April 15, 2021

Re: 10020 Central (Little Caesars Pizza)
10020 Central Ave S.E.
30-Day Temporary Certificate of Occupancy
Transportation Development Final Inspection
Engineer's/Architect's Stamp dated 2-21-20 (L20D073)
Certification dated 4-14-21

Sheet: TCL

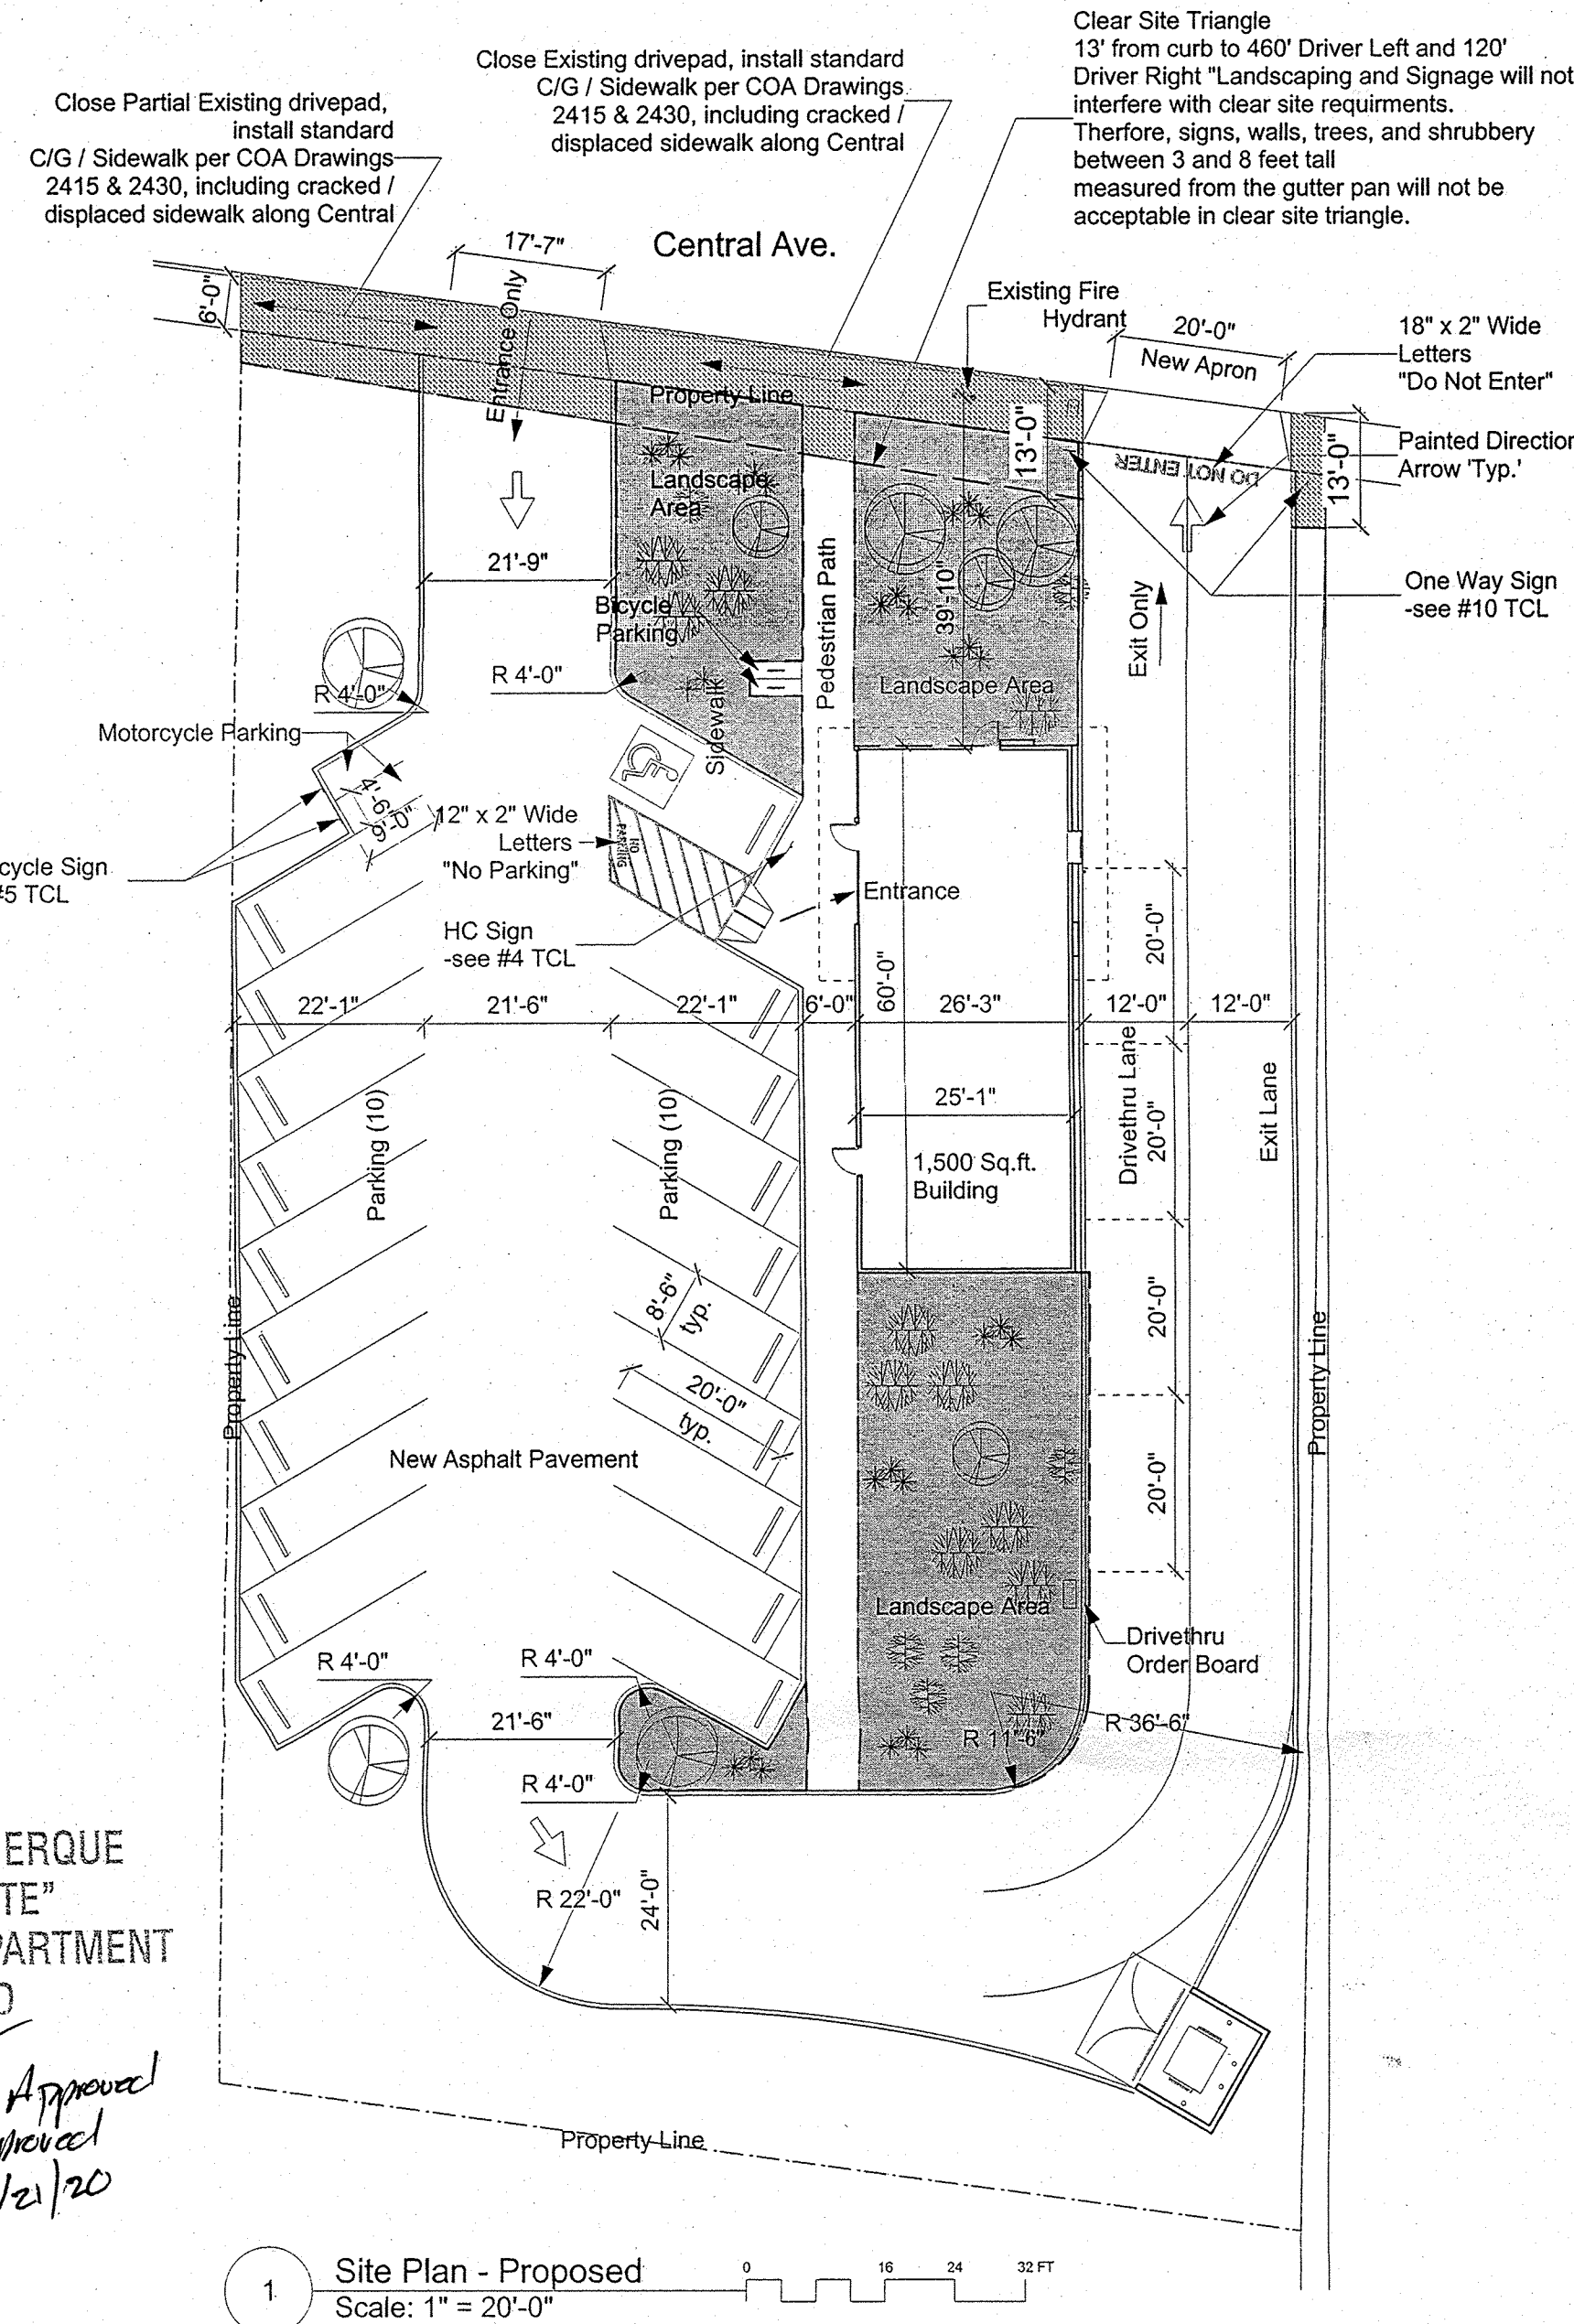
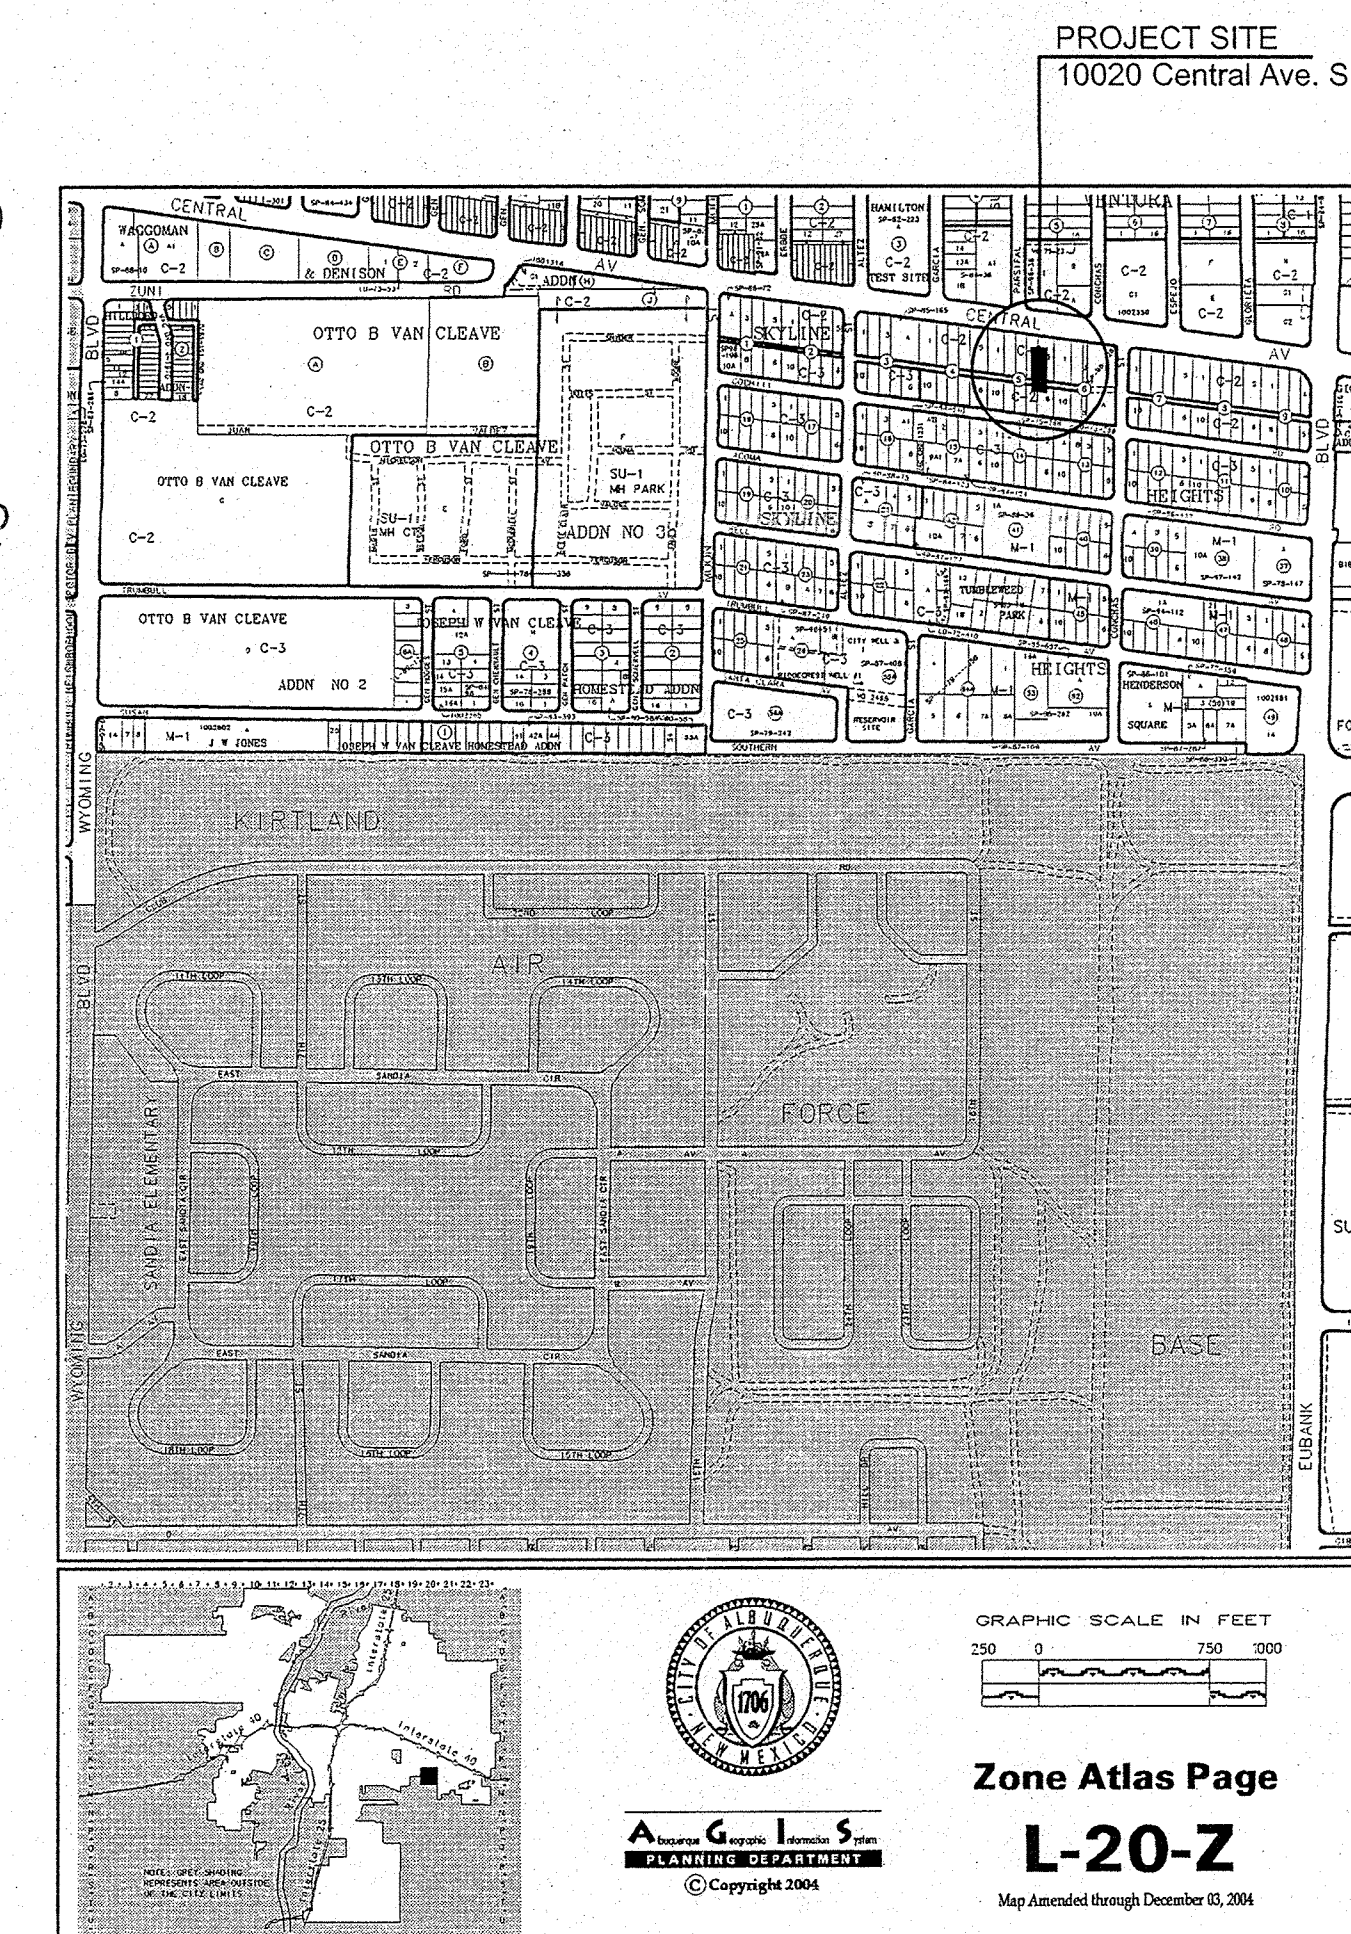
- Please add Bike Rack
- Please remove Construction Debris and equipment from site.
